**Re: 370 Huntmar Drive at Terry Fox Drive  
Site Plan Control Resubmission (Standard)(D07-12-24-0148)**

Minto is pleased to resubmit this Site Plan Control application for your review and comment. This resubmission incorporates City feedback received on February 25, 2025, resulting from a review of completeness on the second submission by Minto on January 27, 2025 (D07-12-24-0148). Responses to City feedback are provided below.

**SHEET NUMBER**  
**C-600**

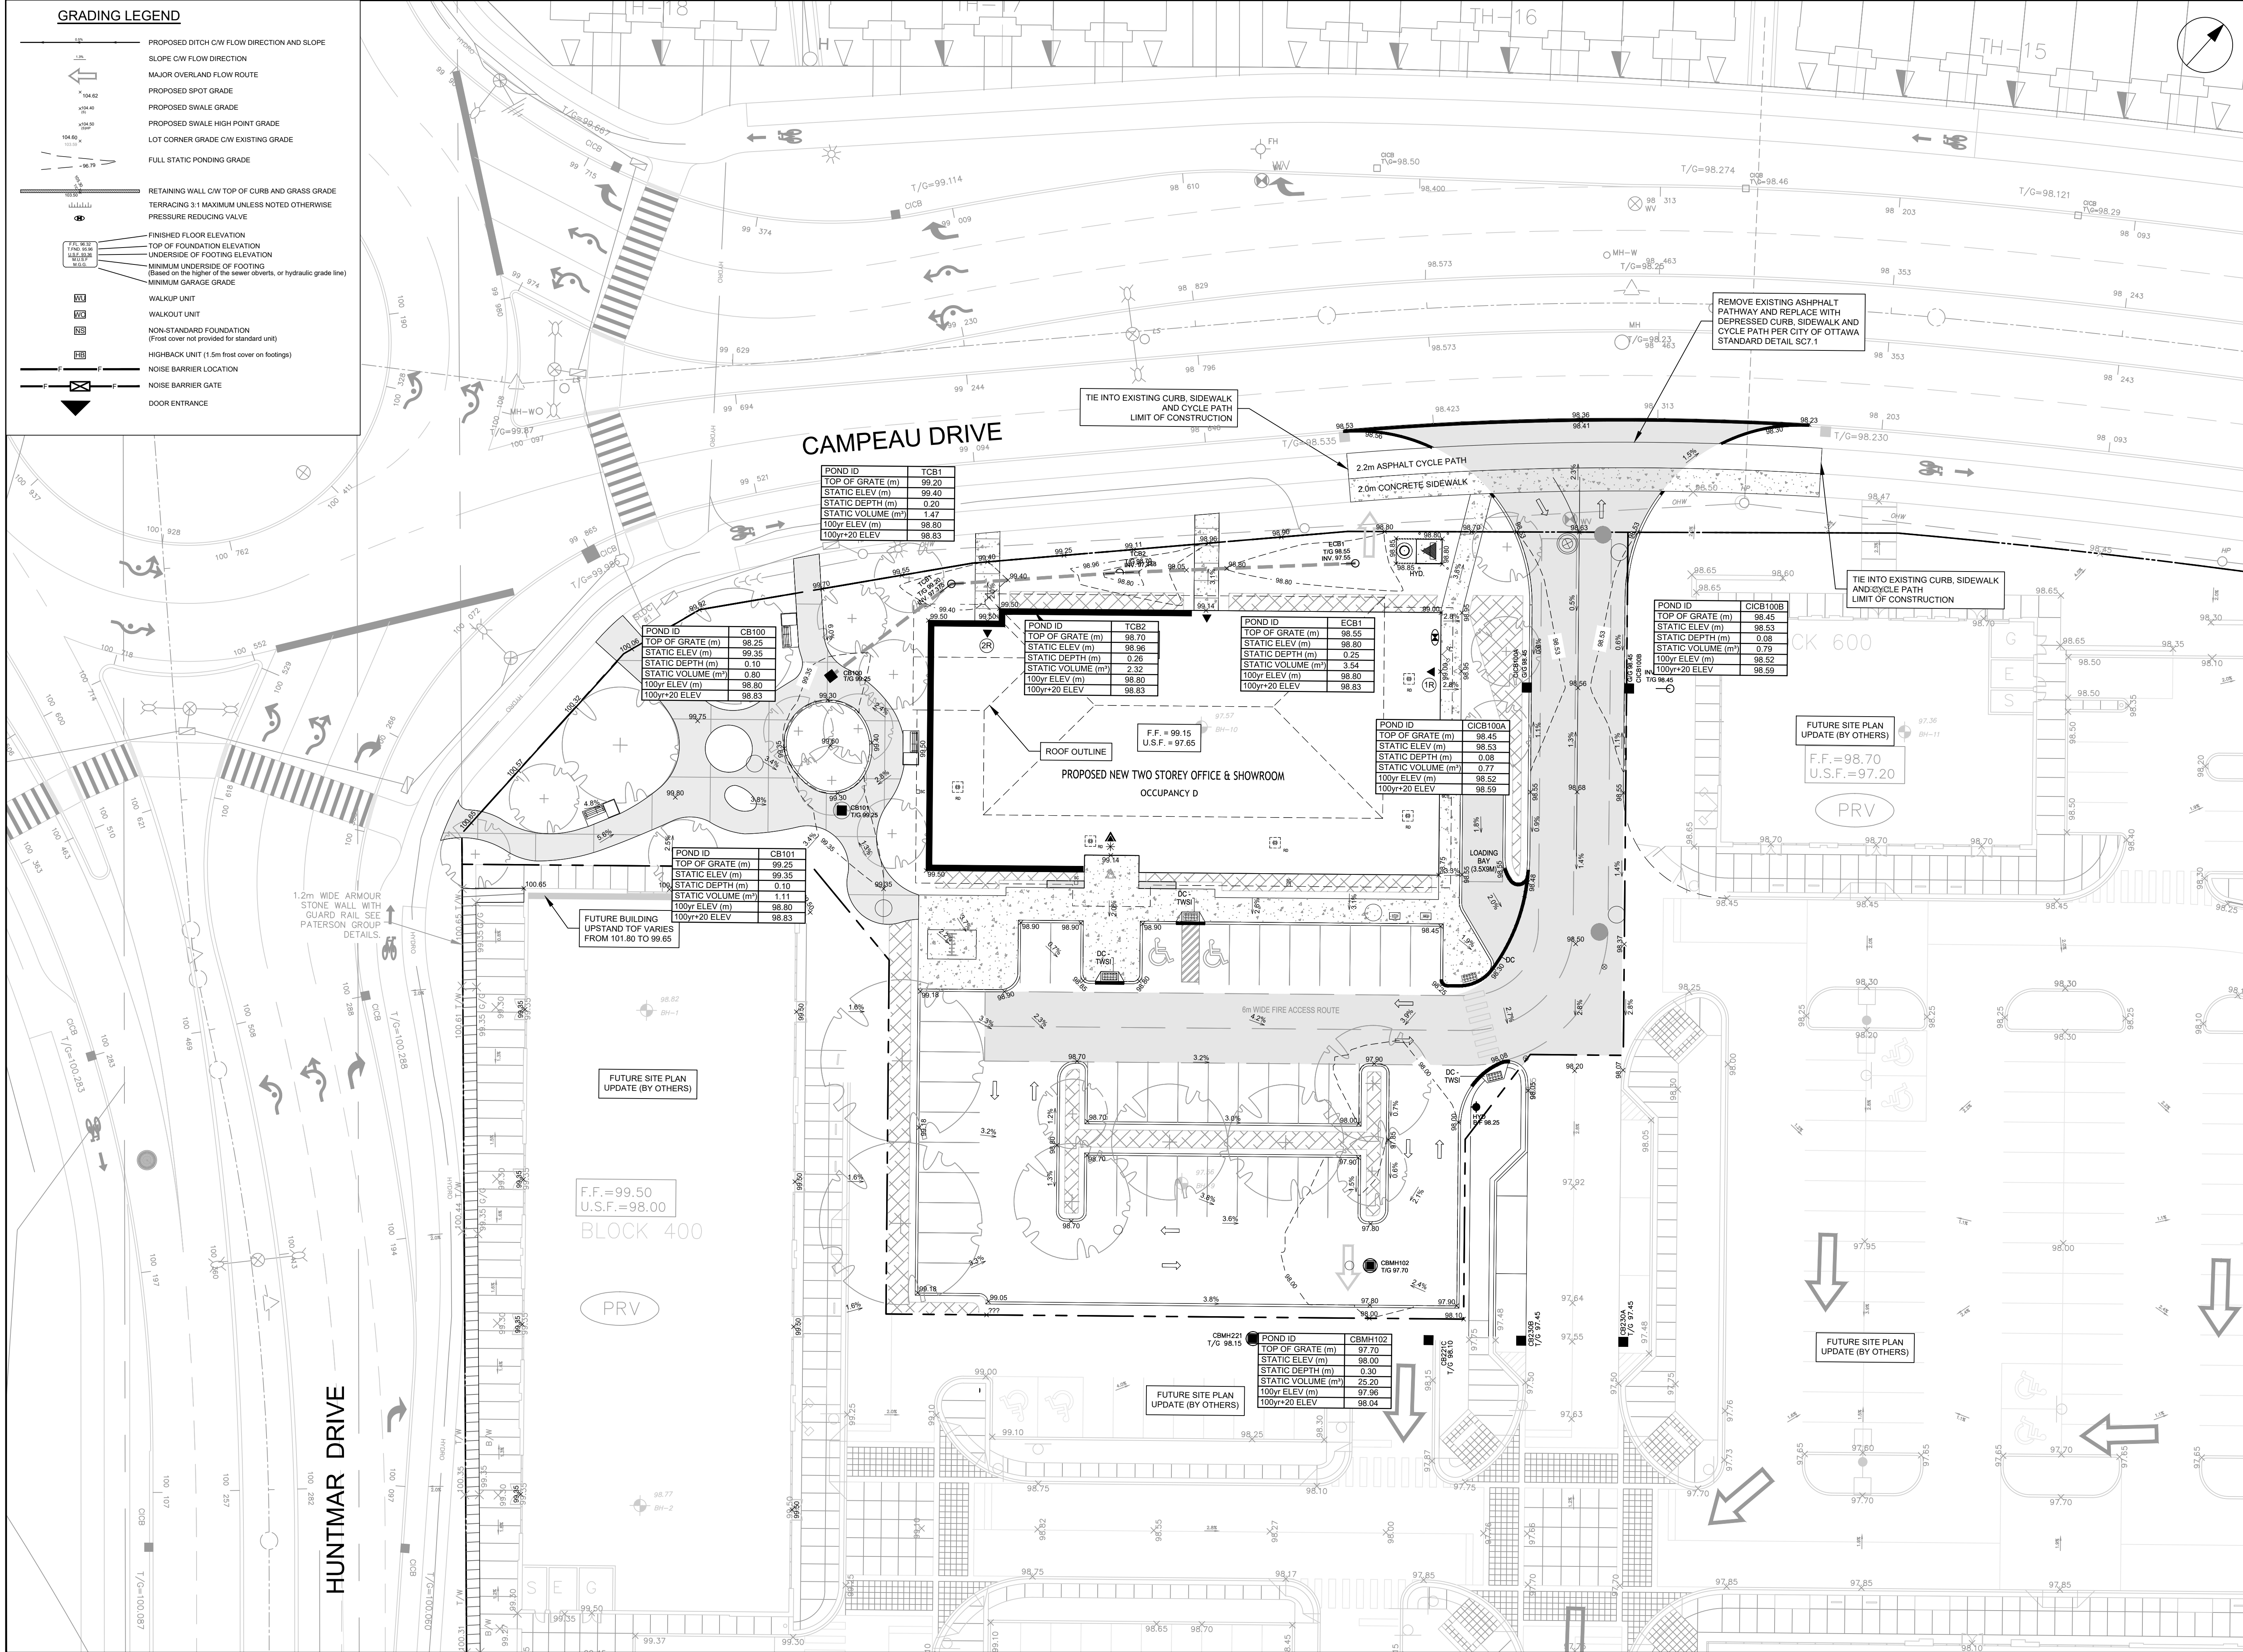
8. **Comment:** Top of grate elevation is 99.25m on C600.

**Response:** Noted. The top-of-pond elevation has been revised to 99.25.

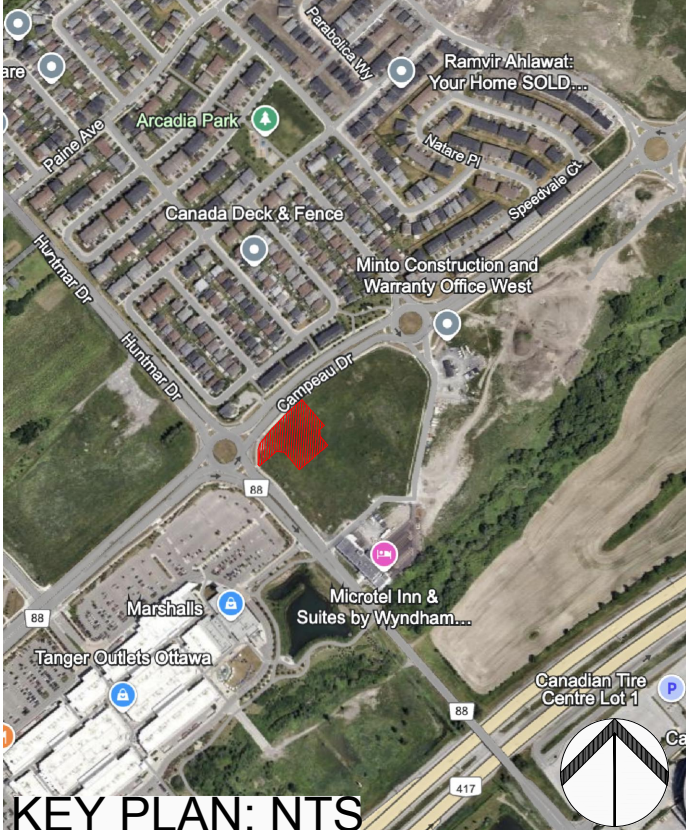
15. **Deficiency:** Demonstrate the available soil volume in restricted planting beds. Most beds are much larger than the required soil volumes for the number of trees proposed and may be suitable for additional planting.

16. **Deficiency:** Please show existing and proposed utilities and other site features, along with their associated setbacks.

17. **Comment:** The geotechnical report identifies low/medium sensitivity SMC on site with recommendations related to tree planting. As per the Landscape Plan TOR, please demonstrate how the planting plan meets the recommendations of the geotechnical report and the Tree Planting in Areas of Sensitive Marine Clay policies. This may require input from other consultants for confirmation.

**Response:** Noted. Please refer to the updated landscape plan (L.1) included in this resubmission.

**Response:** Noted. Setbacks for tree planting from proposed utilities are provided. Please refer to the updated landscape plan (L.1) included in this resubmission.

**Response:** Noted. It has been confirmed that we are able to meet the SMC requirements of the geotechnical report. The 4.5m planting setback is shown on the updated landscape plan (L.1) included in this resubmission.
